Kevin Cox
Crime Prevention Design Advisor
Thames Valley Police Headquarters South
Oxford Road
Kidlington
Oxfordshire
OX5 2NX

REF: P23/V1784/O

Location: Grove Business Park Downsview Road
Wantage OX12 9FF

19 March 2024

# BICESTER MOTION INNOVATION QUARTER - SPY PARKING STRATEGY

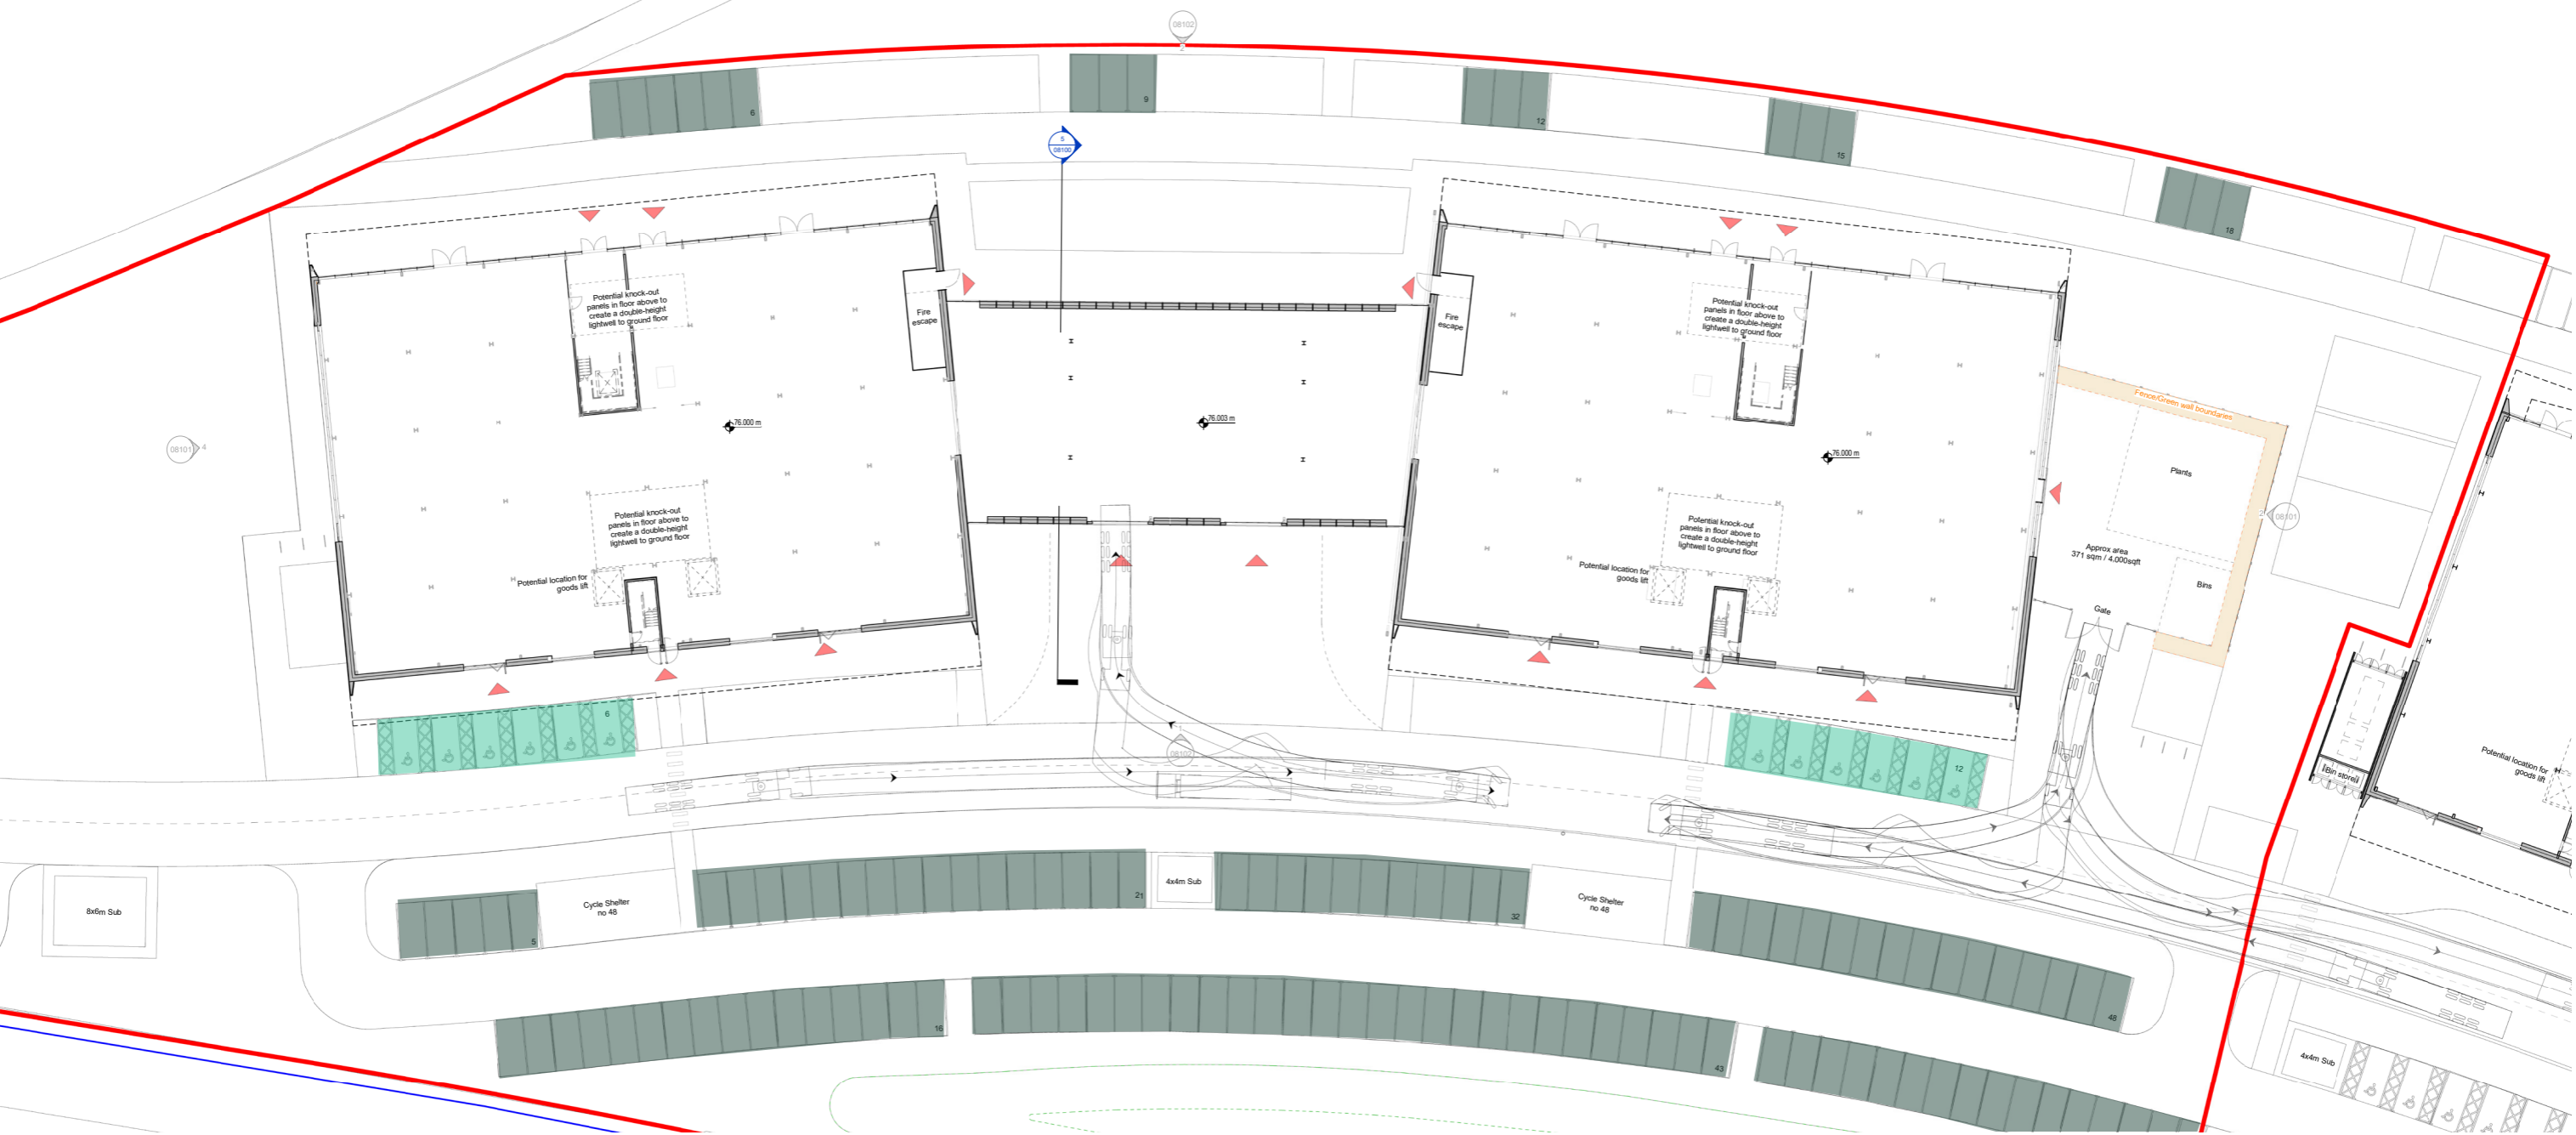
- All parking spaces should be covered by CCTV to deter crime and aid in the detection and prosecution of offenders. CCTV systems should be designed holistically with the planting and lighting scheme to ensure no areas of conflict between these different elements.

- The car parks may be vulnerable to ASB and unauthorised encampments, and should be protected with robust gates or similar to prevent unauthorised access to the car park outside of operating hours.

## PARKING STRATEGY - BICYCLE SHELTER

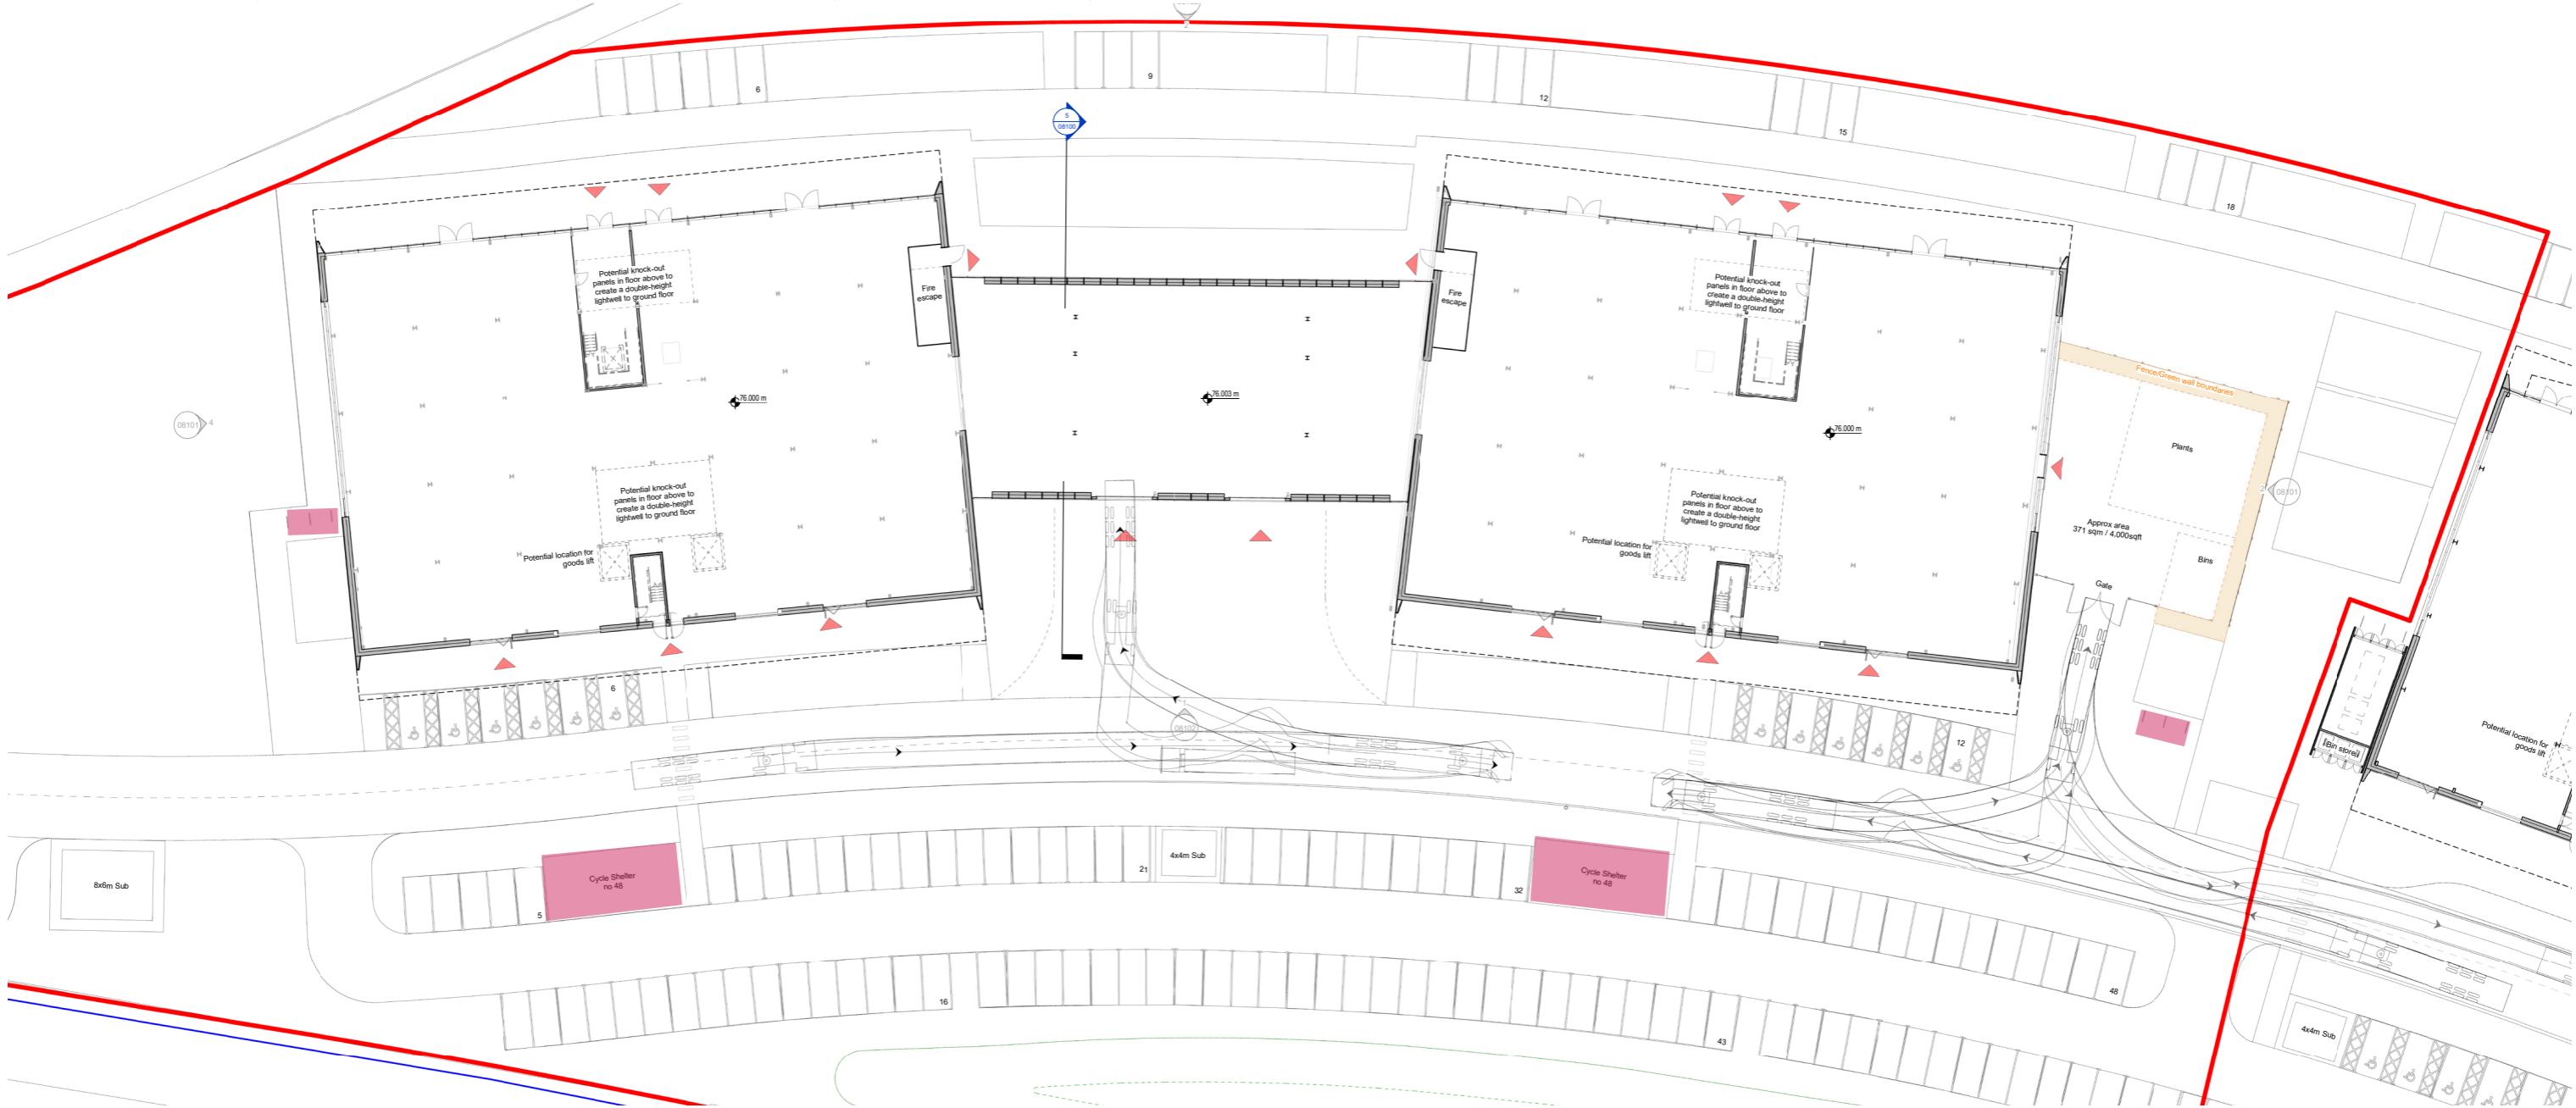
- I am unable to locate any plans for the proposed secure enclosed cycle storage serving this development. Covered stands are suitable for temporary visitor cycle storage, however they must be located close to the entrance of the site where they are well overlooked by high levels of surveillance from the development they serve. I have concerns that some of the proposed locations of stands currently lacks sufficient surveillance to deter theft. I ask that secure enclosed/access controlled cycle storage is provided, which is designed in accordance with the guidance of Secured By Design. Plans should be submitted prior to permission being granted.
- Cycle storage facilities should be covered by CCTV and be lit.

BICESTER MOTION INNOVATION QUARTER - SPY LANDSCAPE DESIGN STRATEGIES - LIGHTING

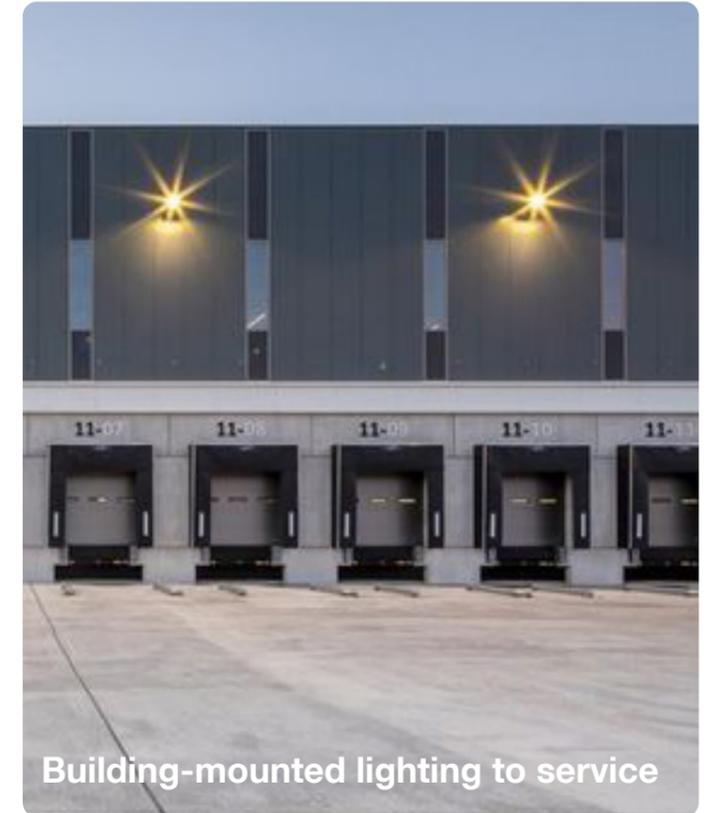
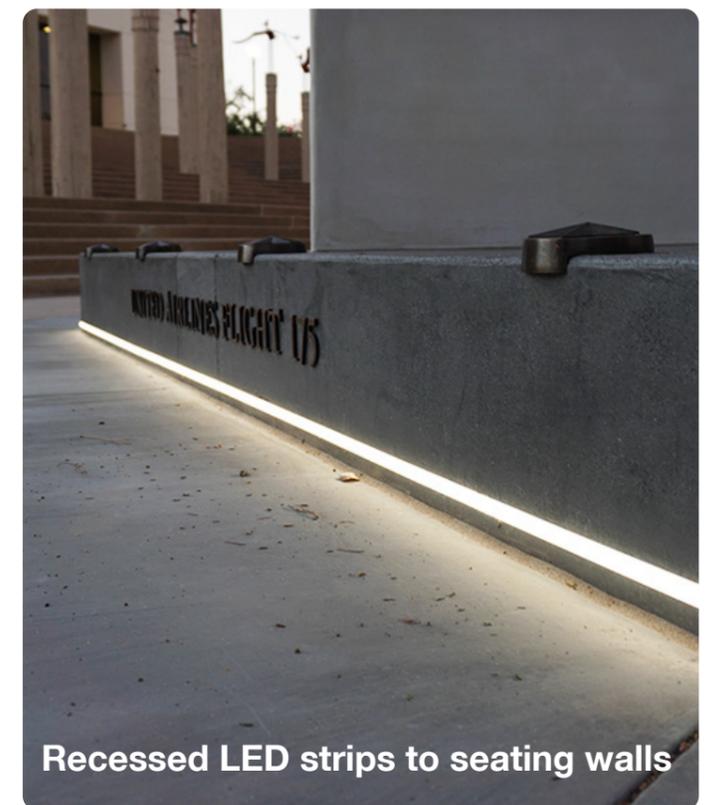
- I am unable to locate any lighting plans within this application, and ask that they are provided prior to permission being granted or secured via the above or similarly worded condition. Lighting throughout the development should meet the general standards of BS5489-1:2020. Bollard lighting used in isolation is not an appropriate lighting method, and should be avoided. Not only can they be damaged by reversing vehicles and vulnerable to criminal damage, more critically they do not provide sufficient light at the right height to aid facial recognition and reduce the fear of crime. It also does not deter crime and antisocial behaviour.
